**PLAN REVIEW SHEET**

Petition #: RZP 2020-070

Address: Ashley Road and Joy Street

Request: UR-2 (CD) to UR-2 (CD) SPA

REZONING SITE PLAN

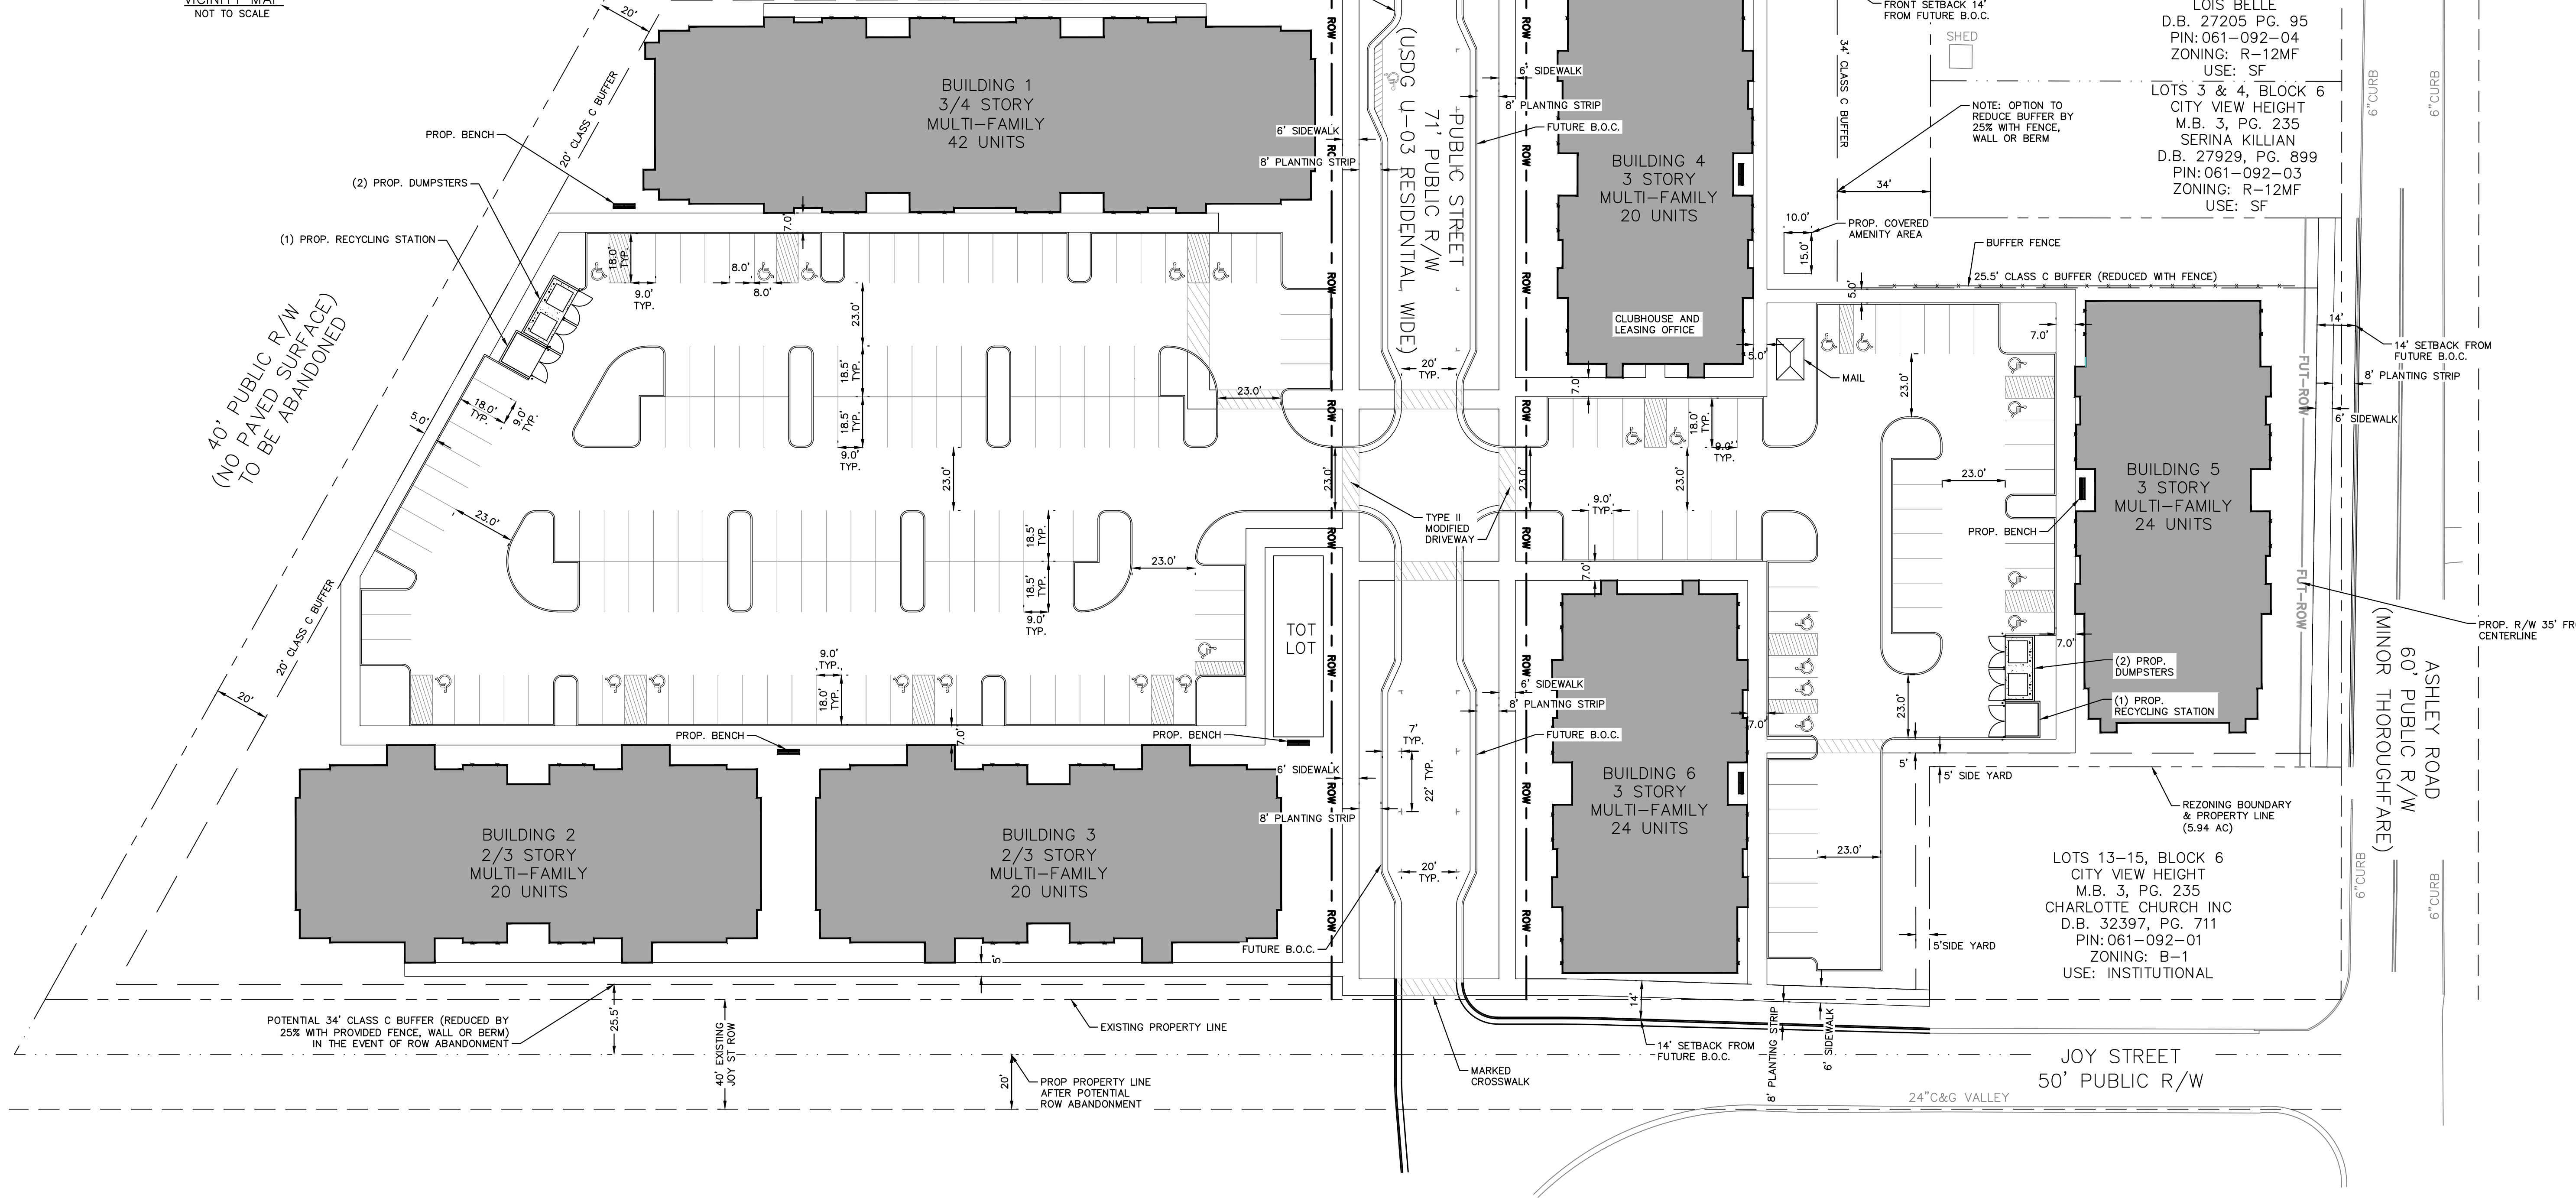
The site is located along CATS local bus routes #2, #235 and #30. CATS requests the petitioner to reconstruct a new ADA compliant bus waiting pad and shelter per Land Development Standard #60.03A along Ashley Road with the goal of consolidating existing stops. The final location of the pad will be coordinated with the developer through the permitting process.
